ENG-PUDSP21010-R3-PDR.pdf Markup Summary

Engineering Review
 4/20/2022 8:22:53 AM
 dsdrice
 dsdrice@pudsp.com
 (719) 530-7877
 EPC Planning & Community
 Development Department

EX-1

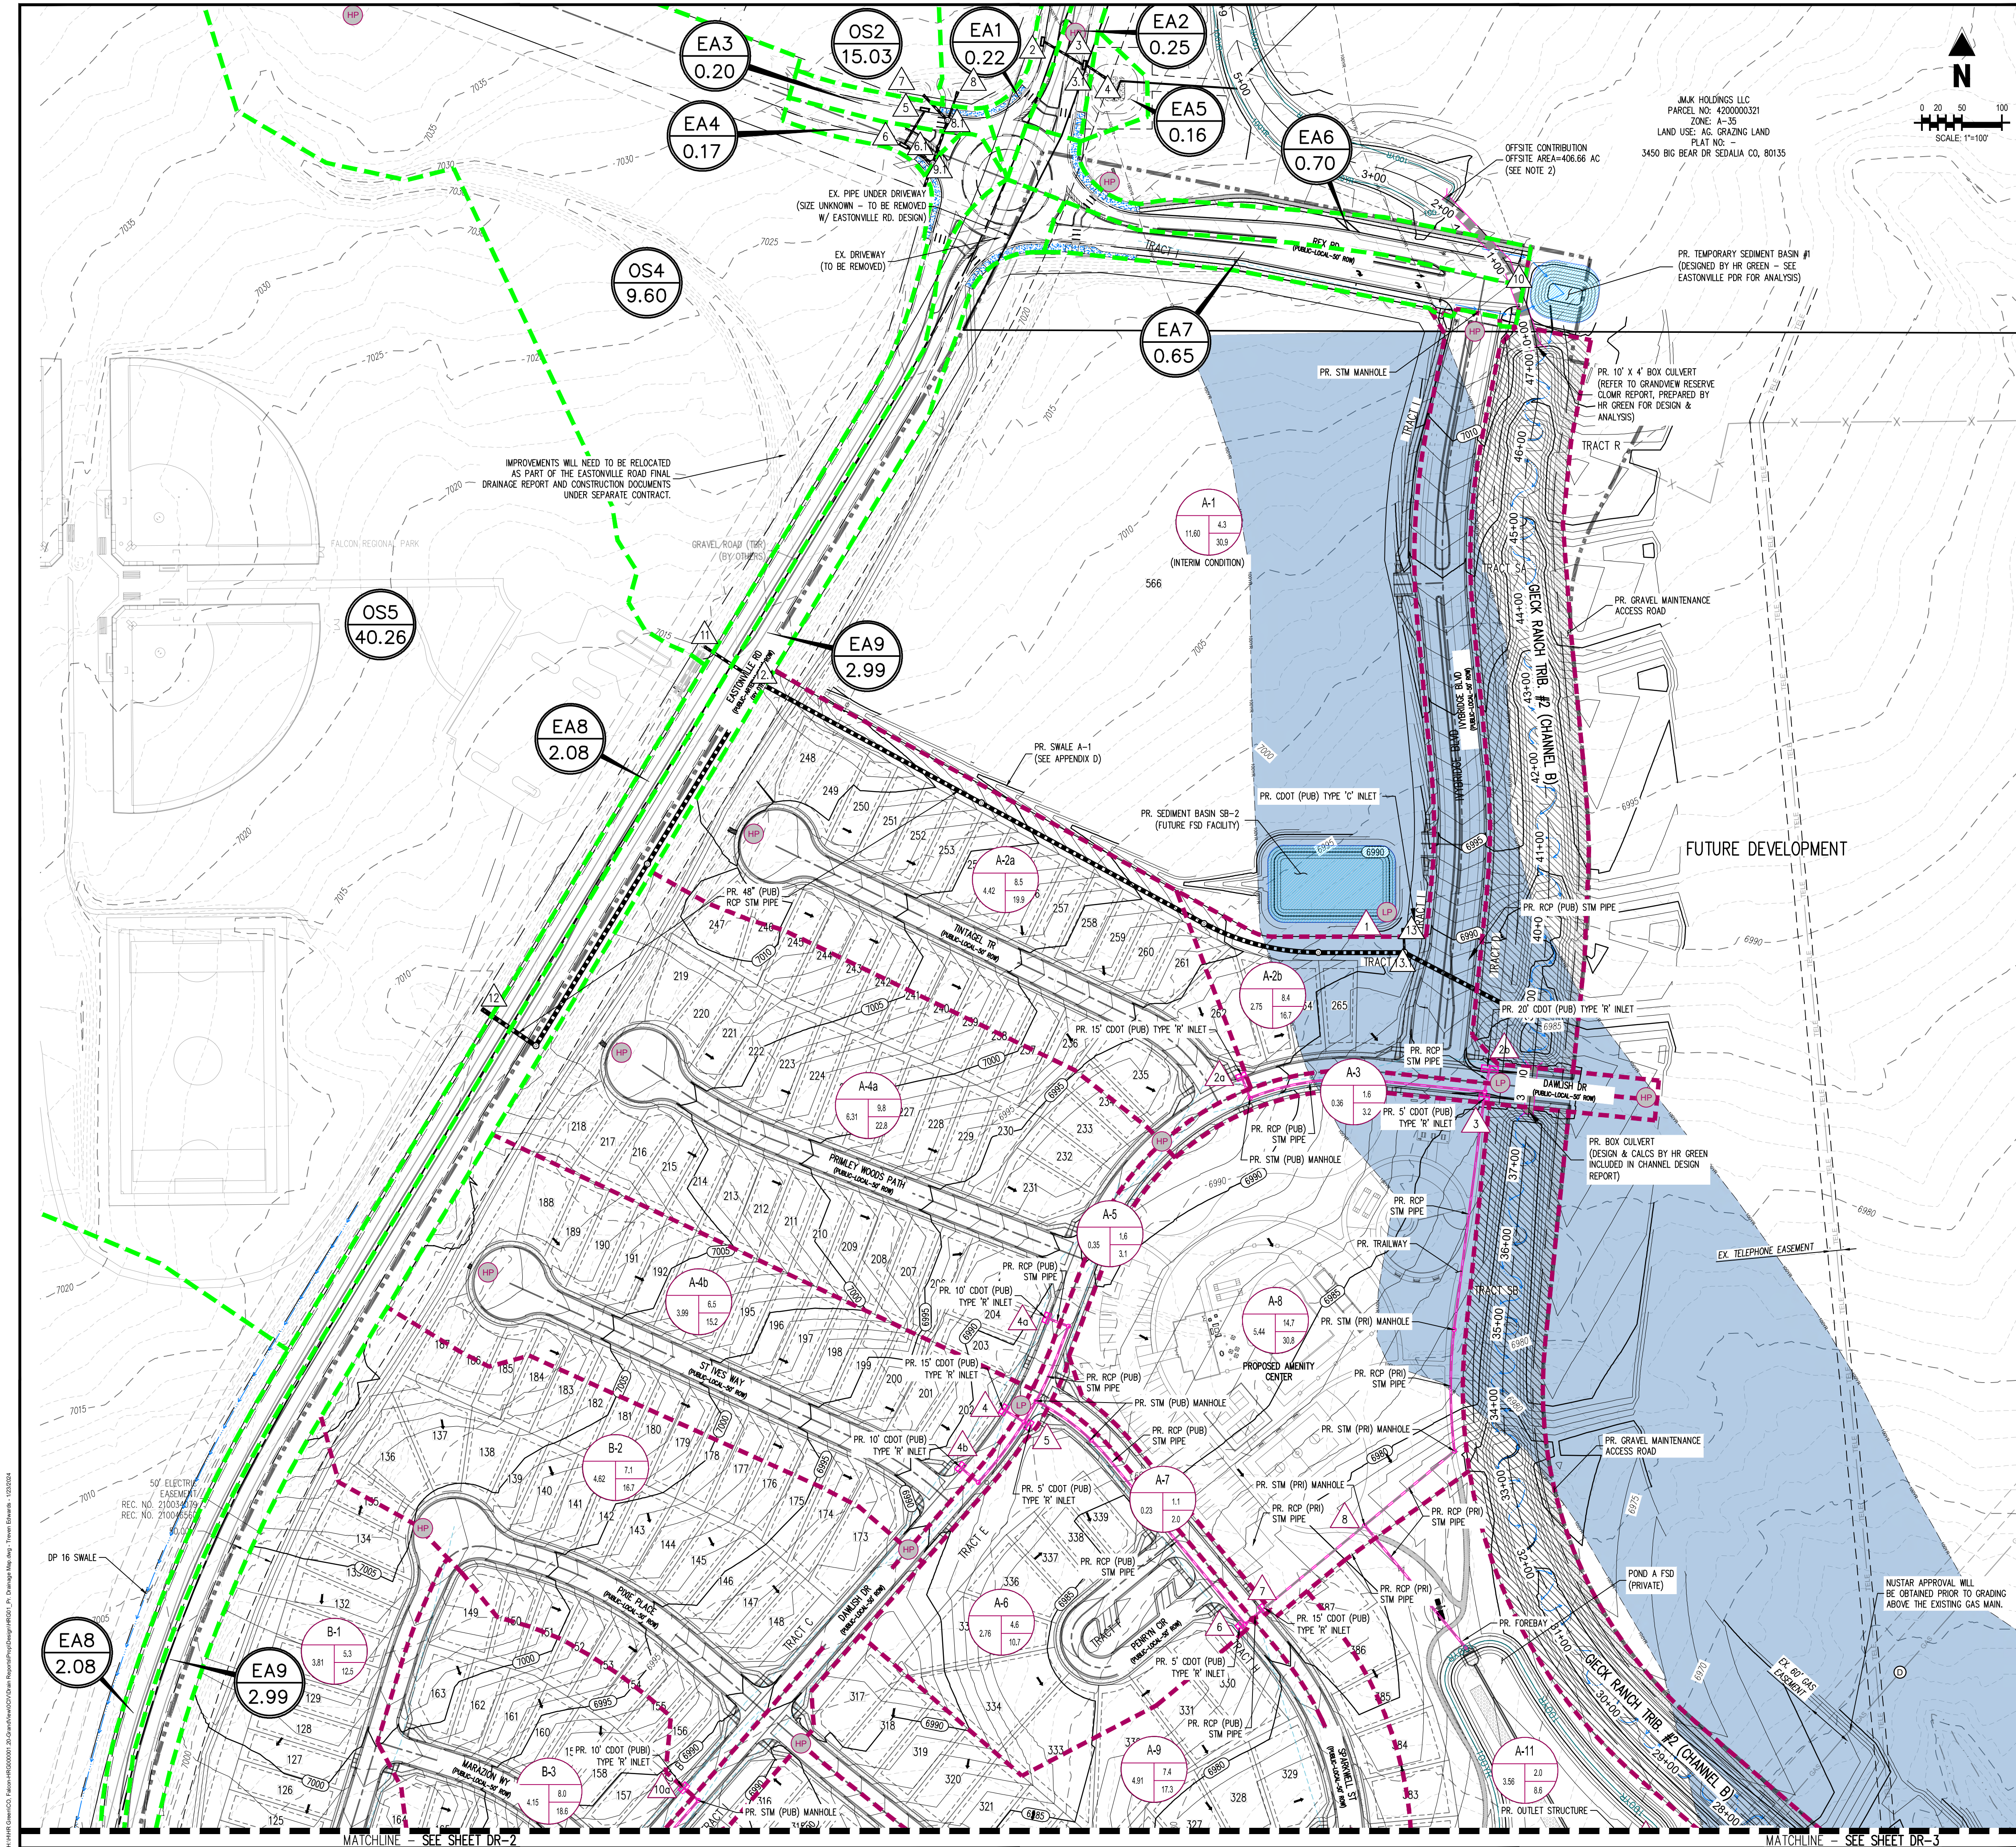
Provide for all existing offsite basins

show culverts and flows

Label flows

Label sub-basin

Label sub-basins

DR-1
Sheet 1 of 3

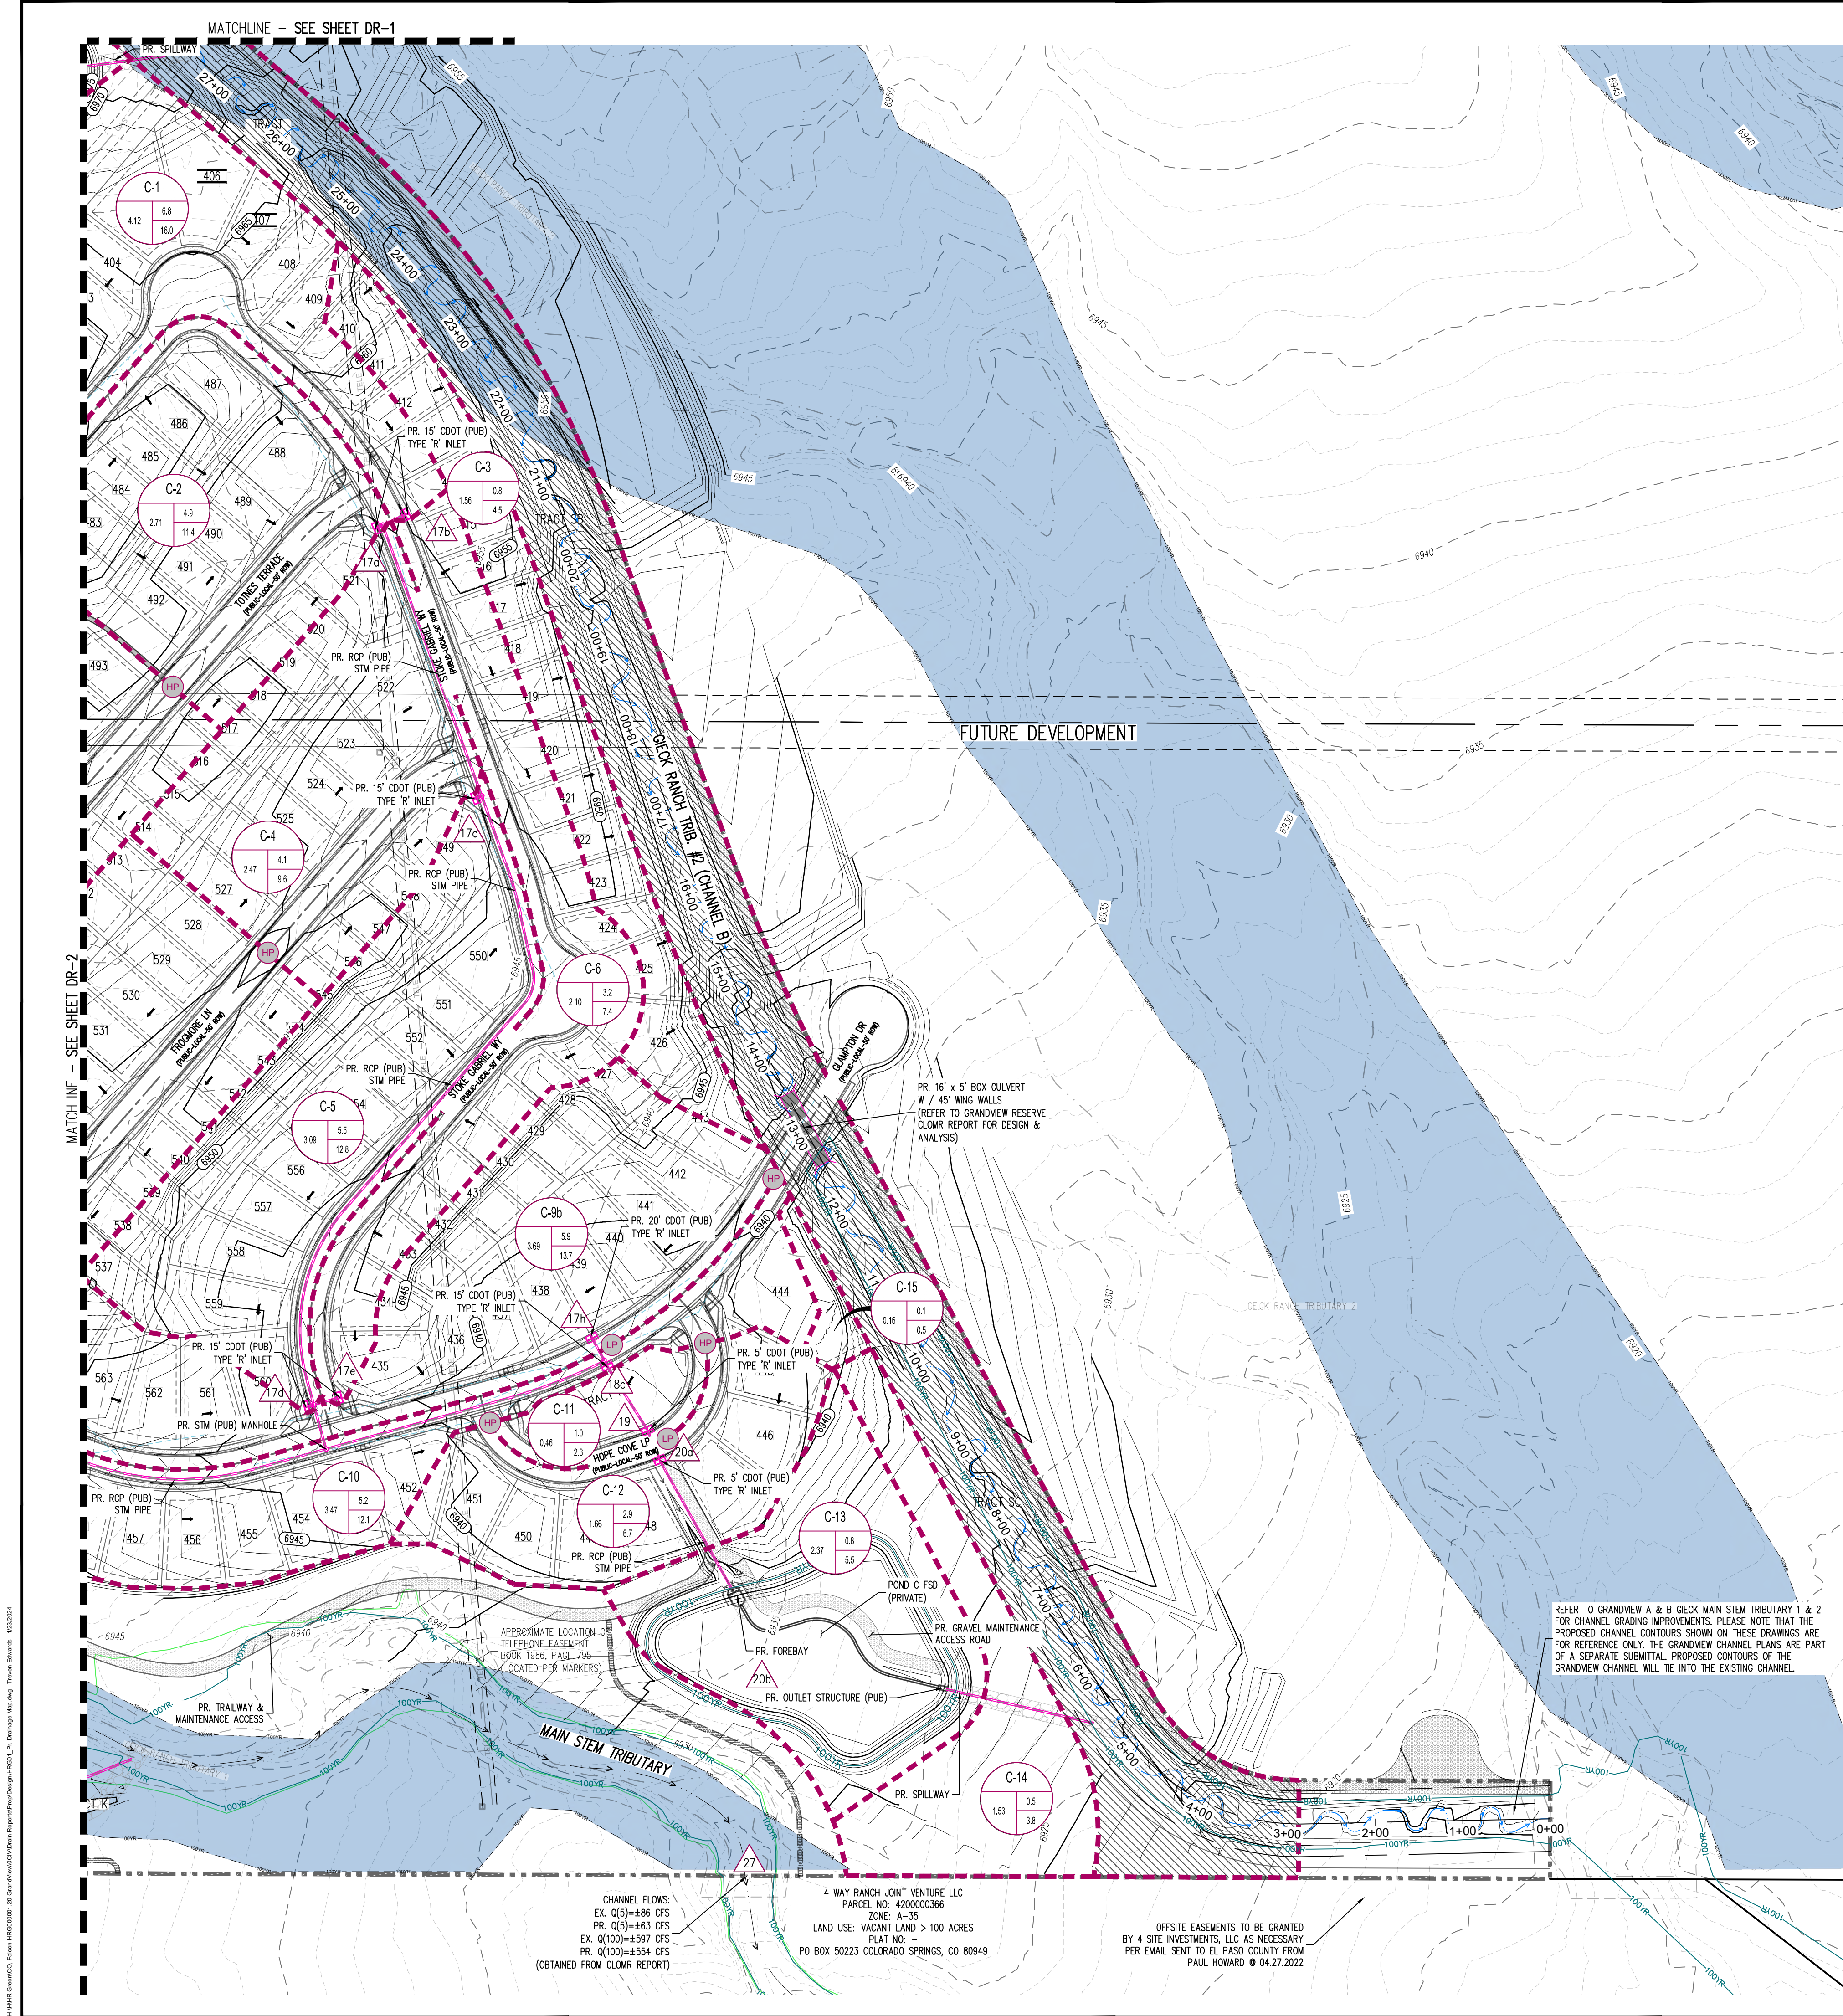
Label the proposed channel construction

Delete access

Report says SFB

A berm can't be used to control the 100-year flood elevation, Add a note that the entire area will be filled with development east of the channel.

Show the 100-year water level in the channel (all sheets)

Provide lot numbers (all sheets)

Address conveyance and flows here

Address where flows from here go, label culvert to be removed if that is the case

Label channel centerline stationing
